# **A1 in Northumberland: Morpeth to Ellingham**

**Scheme Number: TR010059**

## **Applicant's Response to Relevant Representations**

<b>Regulation Reference:</b>	APFP Regulation Rule 8(1)(c)
<b>Planning Inspectorate Scheme Reference</b>	TR010059
<b>Application Document Reference</b>	TR010059/6.7
<b>Author:</b>	A1 in Northumberland: Morpeth to Ellingham Project Team, Highways England

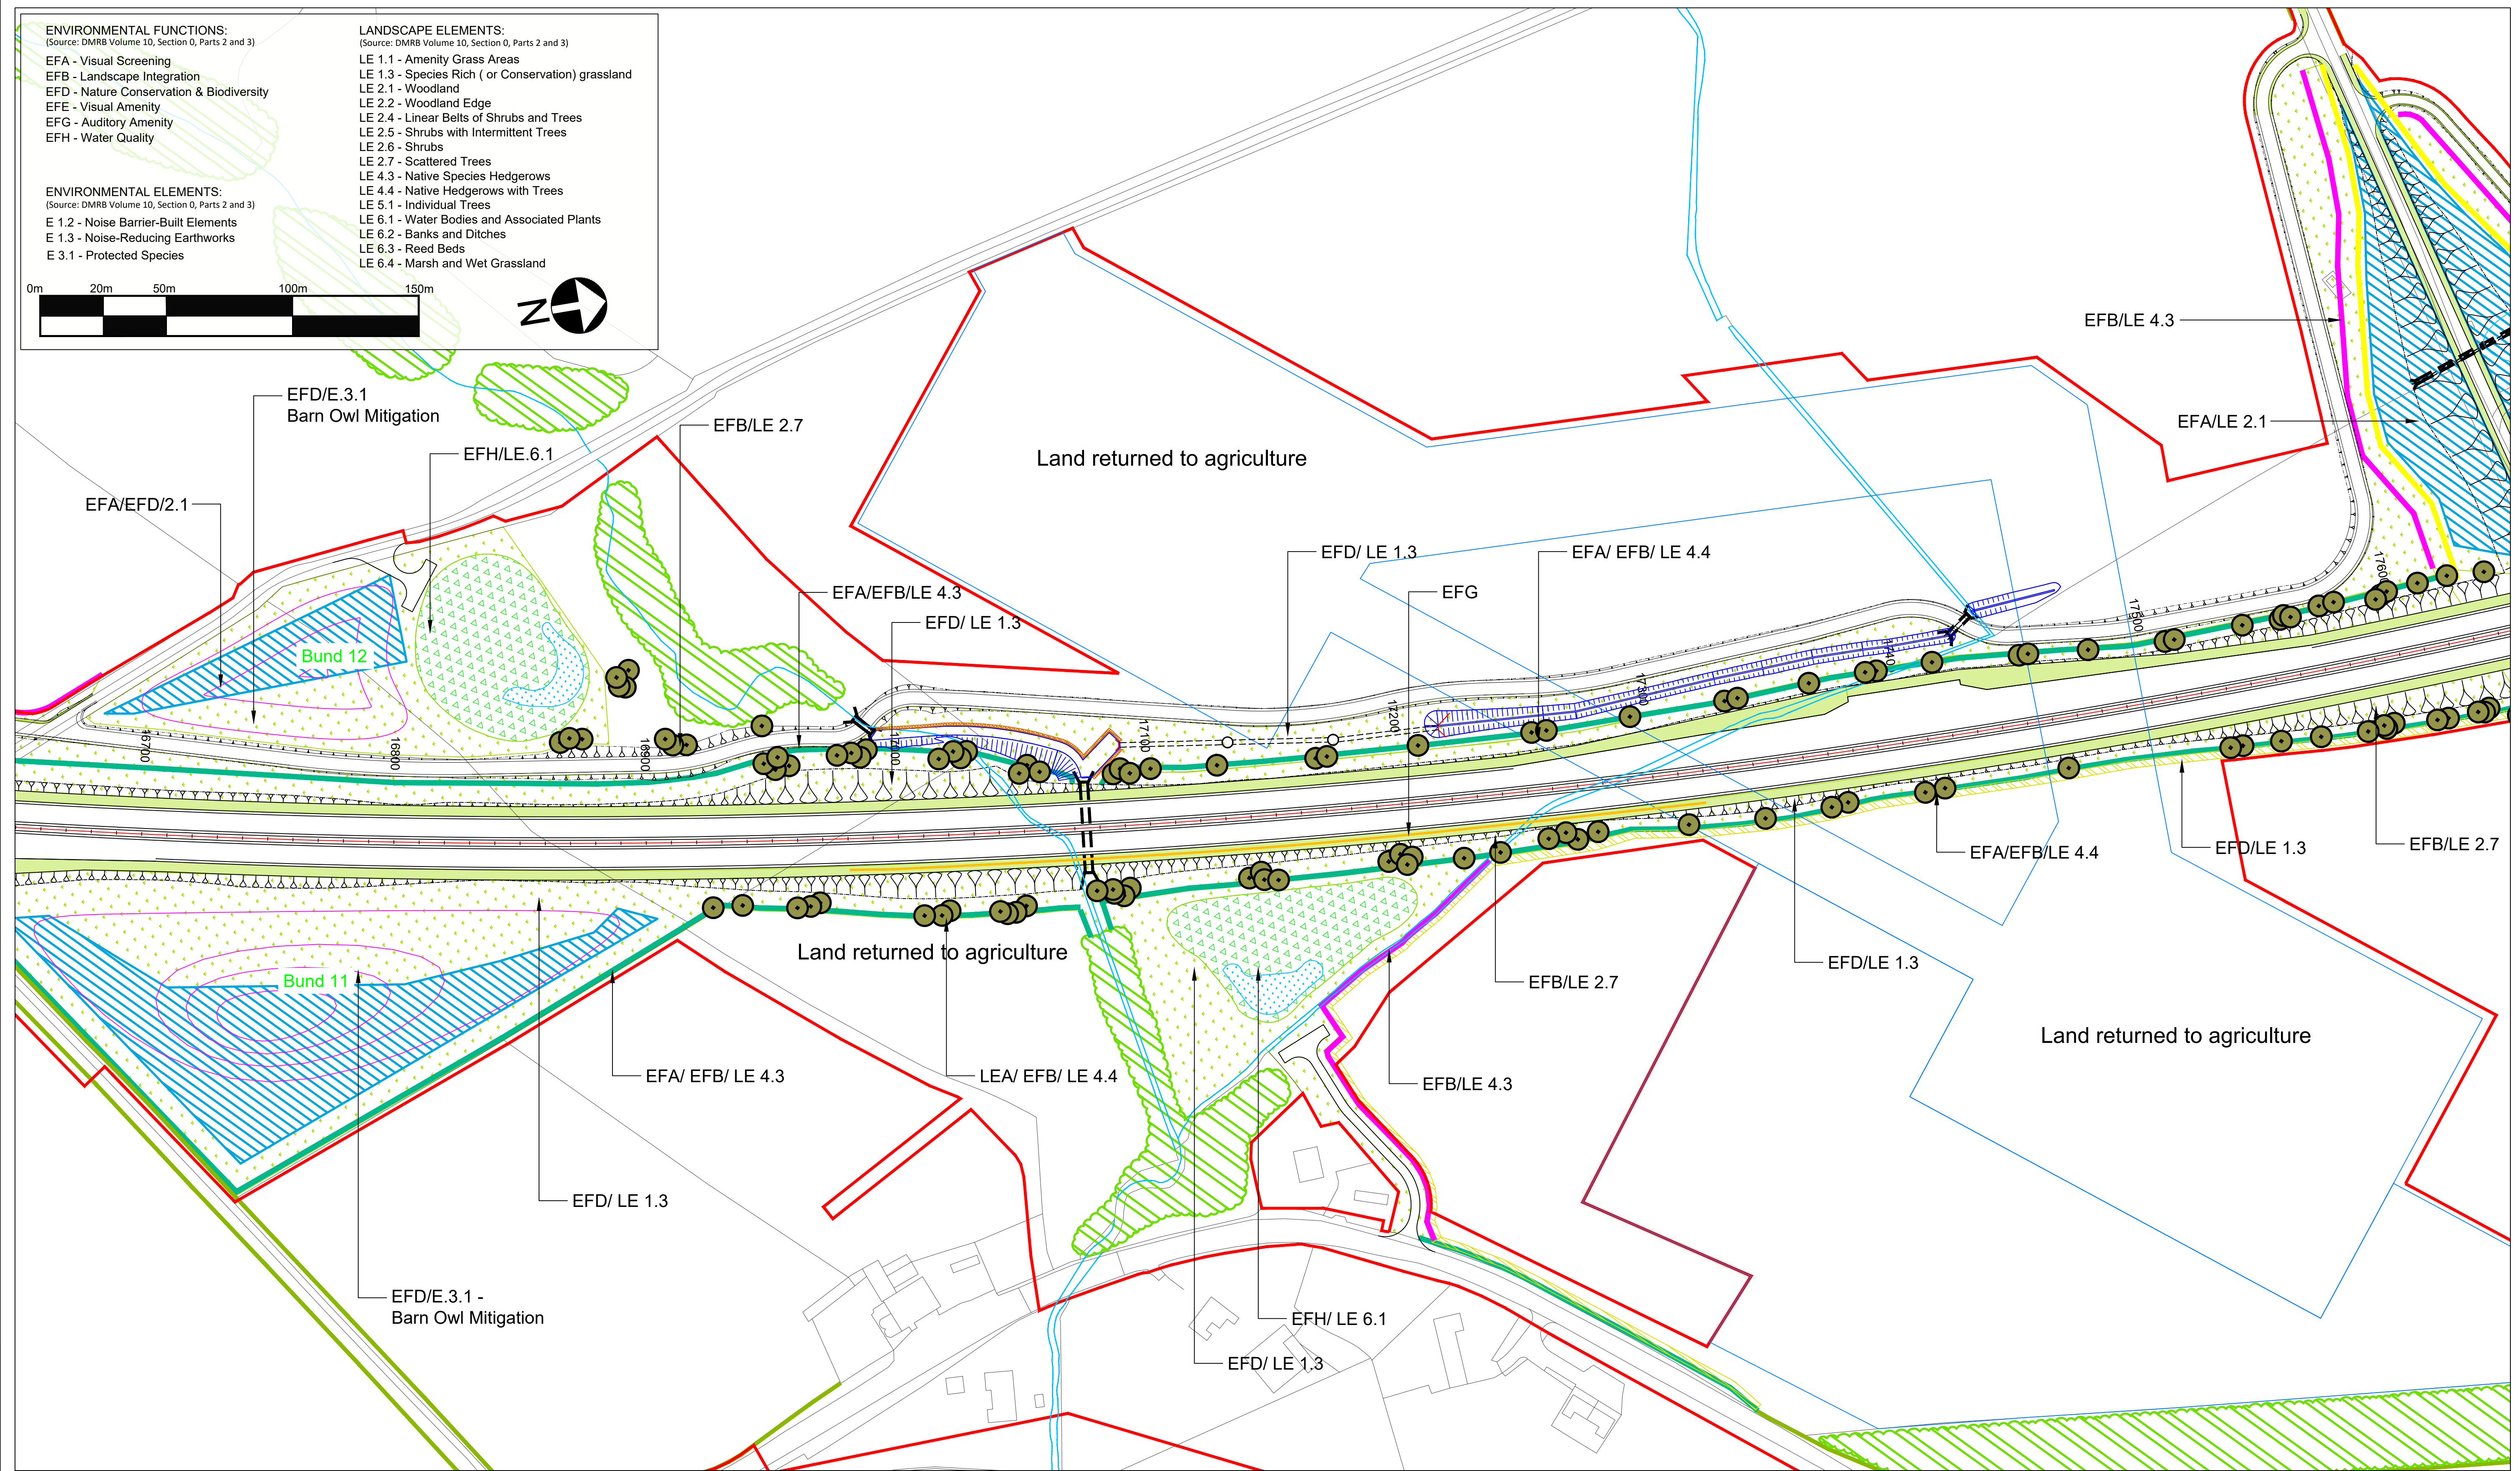
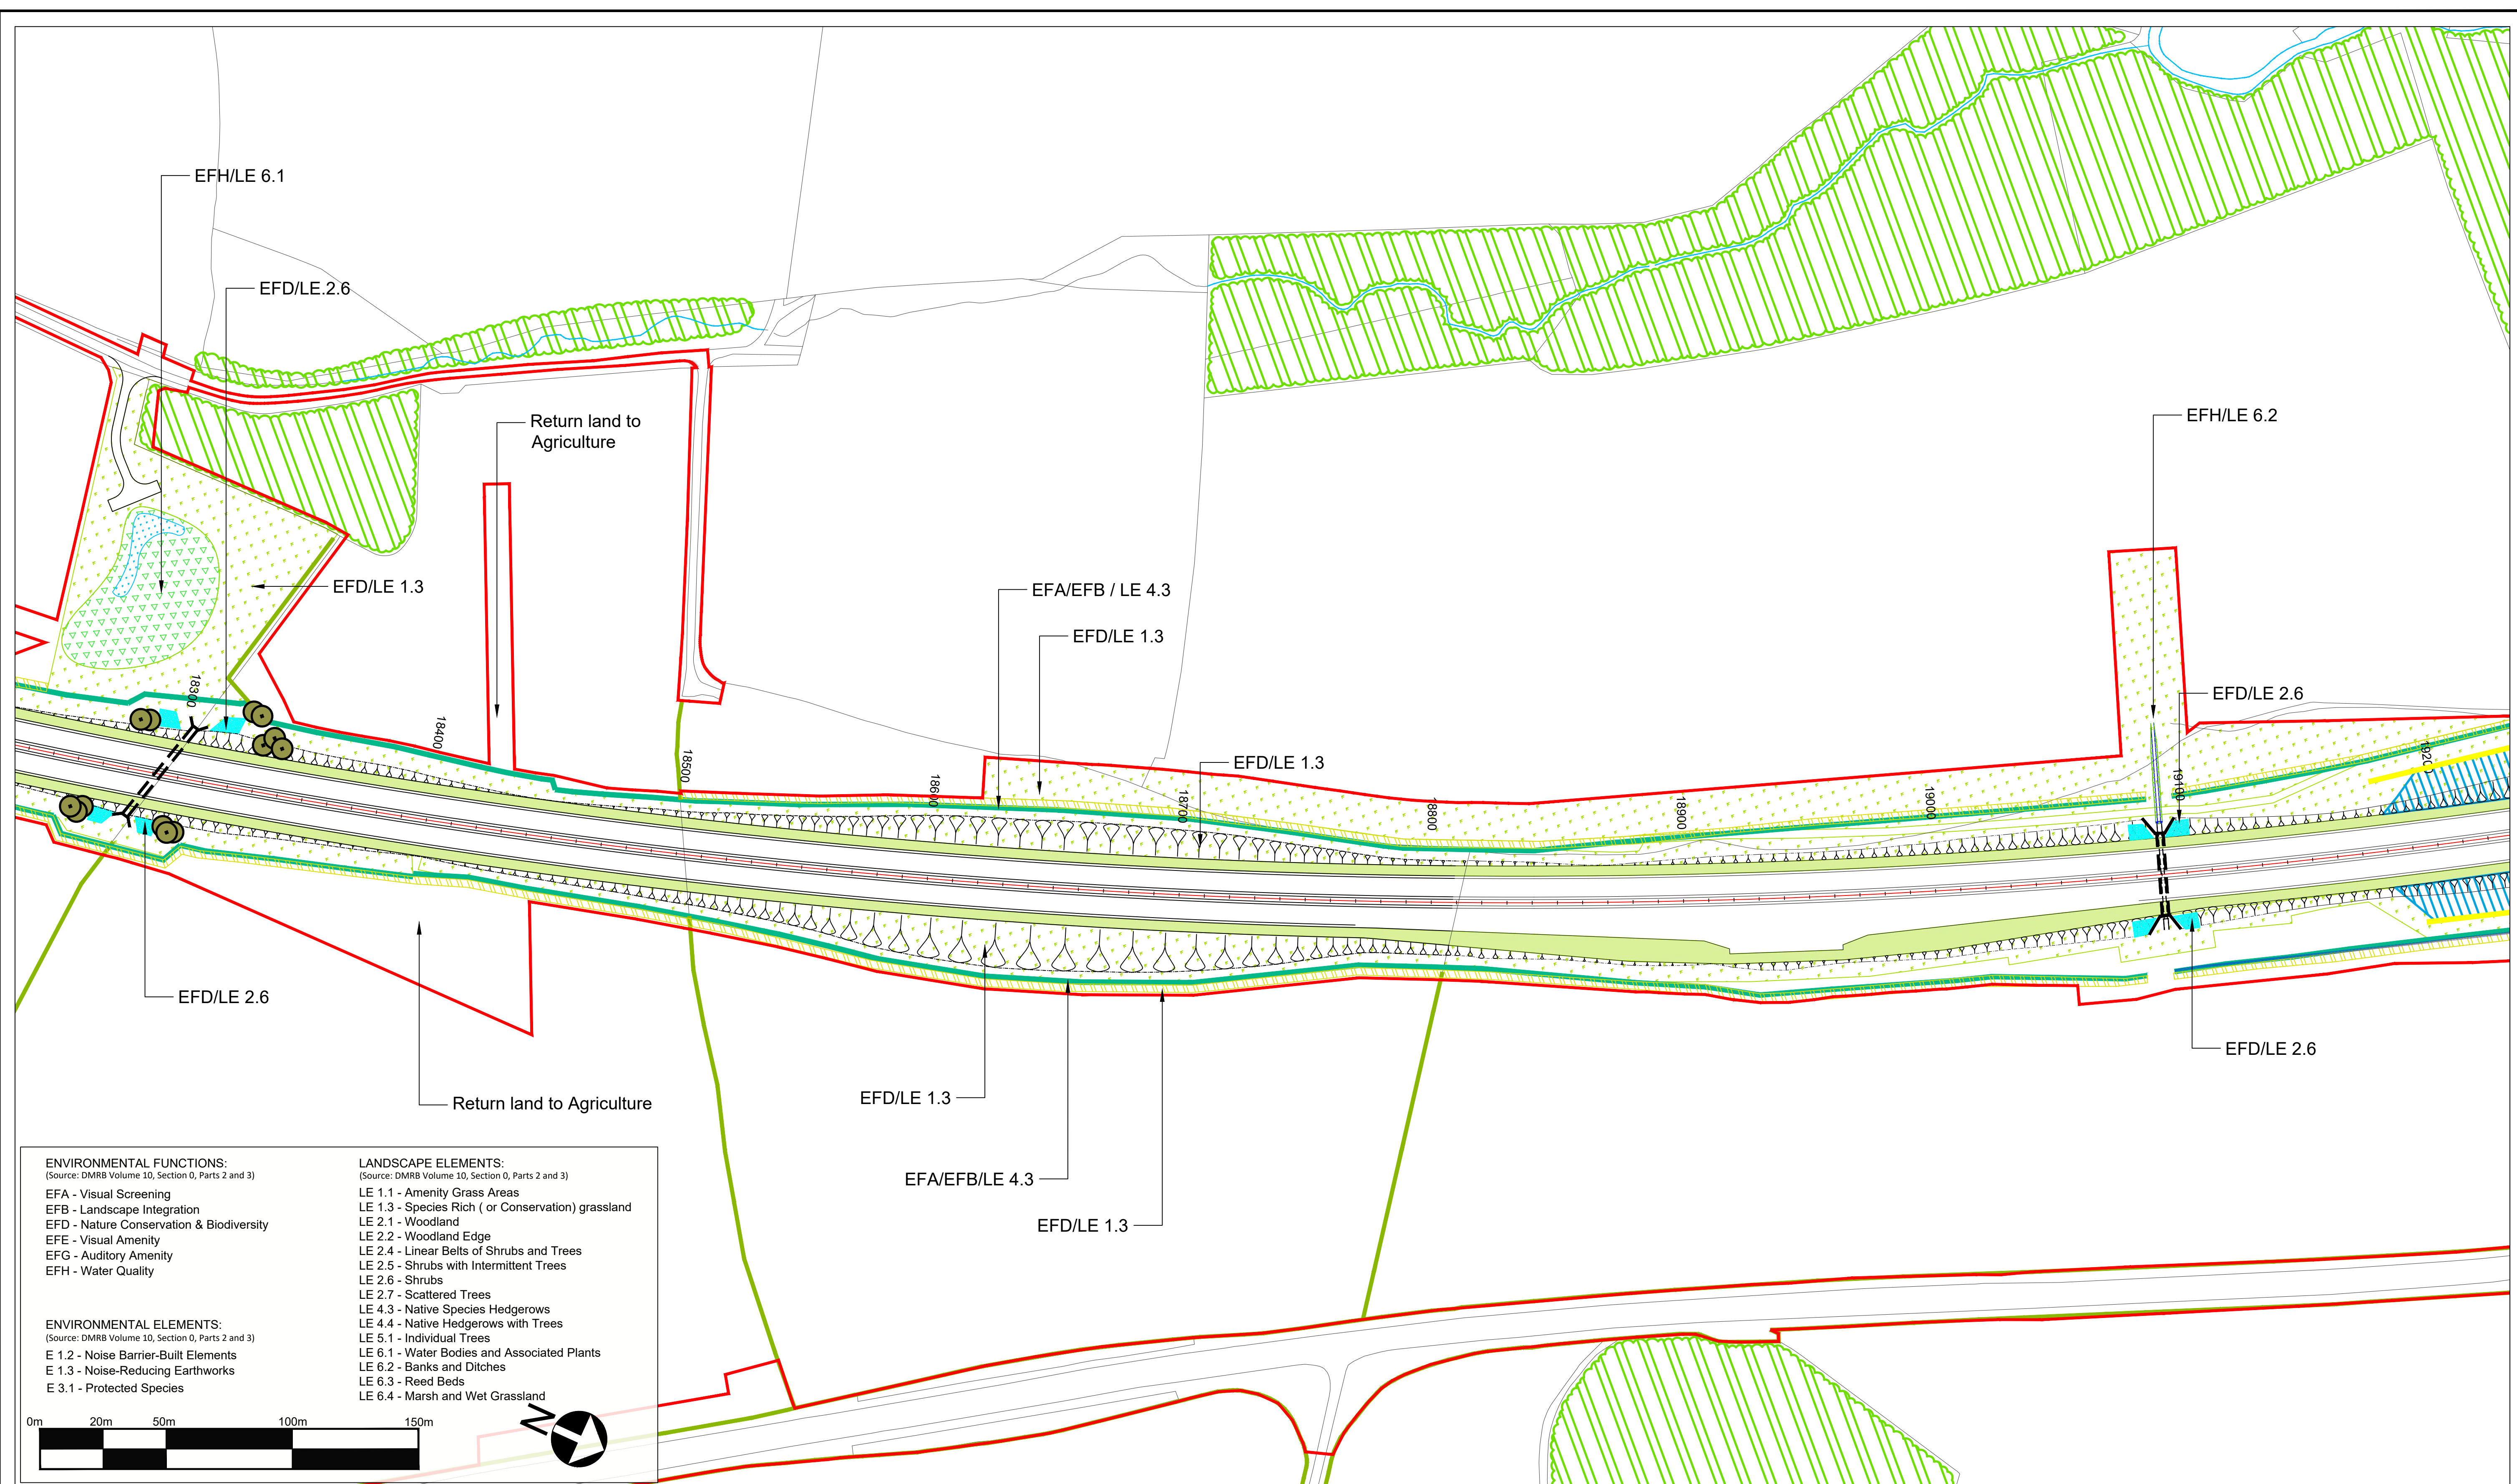
1.1.25	Mitigation for visual effects at Causey Park Bridge appear to be inadequate given the proposals include no vegetative screening for a 4.2m high embankment with a noise fence on top openly seen at a distance of 100-150m from the street and homes. The red line boundary includes an area where planting could have been included to provide some screening.	<ol style="list-style-type: none"> <li>1. The planting strategy associated with Causey Park Bridge does include an element of vegetative screening in the form of a hedge and groups of hedgerow trees that would replicate the existing vegetation to the west of Causey Park Bridge, reflecting the existing characteristics and interrupting views towards the Scheme. In establishing the landscape proposals as set out on Figure 7.8: Landscape Mitigation Masterplan Part A, [APP-095] the Applicant considered that provision of more extensive blocks of planting (trees and shrubs) or long linear belts of woodland, as suggested by NCC, would not be appropriate, as this would substantially change the characteristics and setting to the settlement. These are typically absent within the immediate area, and substantially increasing tree cover would change the open nature of the landscape to the west of Causey Park Bridge. The embankment and specifically the proposed noise barrier would be within the line of sight from receptors within Causey Park Bridge and are anticipated to screen traffic movements. However, despite this, it is anticipated that the effects on the receptors with west facing elevations would be significant during construction and in winter Yr 1, and would remain significant in the summer Yr 15.</li> <li>2. The negative visual effects arising on receptors forming the Causey Park Bridge community could be mitigated further through the adoption of further planting. However, taking the negative effects on landscape character that would arise as a result of the combination of the Scheme and the changes to the open characteristics of the landscape as a result of more extensive blocks of planting (trees and shrubs) or long linear belts of woodland, the proposed mitigation strategy, outlined in Figure 7.8:</li> </ol>

1.1.30	There is an ecological bias to the landscape design, both in narrative and in the resultant design. No information has been provided regarding species selection or management or	<ol style="list-style-type: none"> <li>1. The landscape design is not biased towards ecological mitigation but has sought to reflect the relationship between the different aspects of the assessment. The Applicant has developed the landscape and visual mitigation proposals, set out in Figure 7.8 Landscape Mitigation Masterplan Part</li> </ol>

Reference	Comment from Relevant Representation	Applicant's Response
		Landscape Mitigation Masterplan Part A, [APP-095] is the most appropriate option in terms of landscape character.

Reference	Comment from Relevant Representation	Applicant's Response
	consideration of this in terms of mitigation of landscape and visual effects.	<p>A [APP-095] and Figure 7.10 Landscape Mitigation Plan Part B [APP-144], to address where appropriate, the landscape and visual effects identified during the assessment. These proposals have been developed alongside the project ecologists, as there is a relationship between the landscape, visual and ecological effects arising as a result of the Scheme, and the provision of mitigation measures provided for landscape character or visual effects mitigation must also serve to provide sufficient replacement habitat.</p> <ol style="list-style-type: none"> <li>2. The Applicant has, within Section 7.9 Design, Mitigation and Enhancement Measures, of both Chapter 7: Landscape and Visual, Part A [APP-044] and Chapter 7: Landscape and Visual, Part B [APP-045], stated how embedded mitigation and specific mitigation measures to address landscape and visual effects should be incorporated into the detailed design.</li> <li>3. Issues of species selection would be addressed at the detailed design stage based on this requirement but would reflect the species found locally and would comprise native species, this is identified in:</li> <li>4. Part A: <ul style="list-style-type: none"> <li>• Paragraph 7.9.14, item c, native tree and shrub species would be in keeping with local landscape character</li> </ul> </li> <li>5. Part B: <ul style="list-style-type: none"> <li>• Paragraph 7.9.4, item c, the incorporation of species rich hedgerows</li> <li>• Paragraph 7.9.13, items b and f, the incorporation of native species in keeping with the local landscape character.</li> </ul> </li> <li>6. Depending upon the species selected and the final design of the measures to deliver mitigation, the management of the mitigation features would be included within a landscape scheme to be approved by the SoS following consultation with NCC, as part of Schedule 2, Requirement 5 of the draft DCO. These measures are secured within the items S-L1 – S-L5, S-L9 of Table 3-1 - Register of Environmental Actions and Commitments: The Scheme, in the Outline CEMP [APP-346]. Mitigation measures would be monitored during the establishment period to ensure their delivery through items S-L11 – S-L13 of the same document.</li> <li>7. In addition, the Outline CEMP [APP-346], prepared and updated through the design and delivery phases would be subsequently converted to a Handover Environmental Management Plan (HEMP) to secure the long-term establishment of the mitigation measures required by the Scheme. Mitigation measures would be monitored during the establishment period to ensure their delivery through items S-L11 – S-L13 of the same document.</li> </ol>
